Sent: 02 January 2026 11:29
To: DC Admin
Subject: planning application 2025/93387 objection

FLOOR PLAN

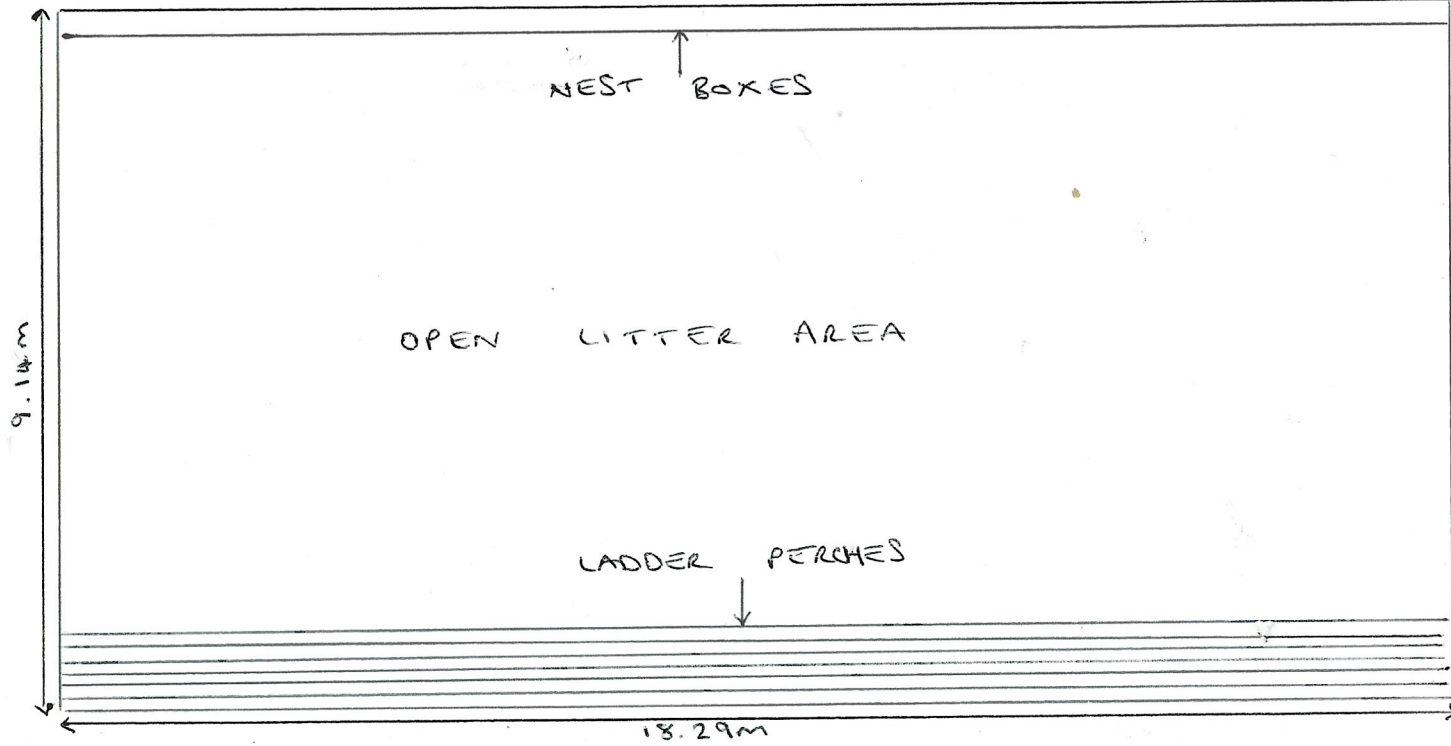
The plans show a building with one large door and no concrete base, no plans for bunded area and no water supply apart from roof run off, that is located on a slope uphill from the main community only approximately 60 meters as the crow flies from dwellings.
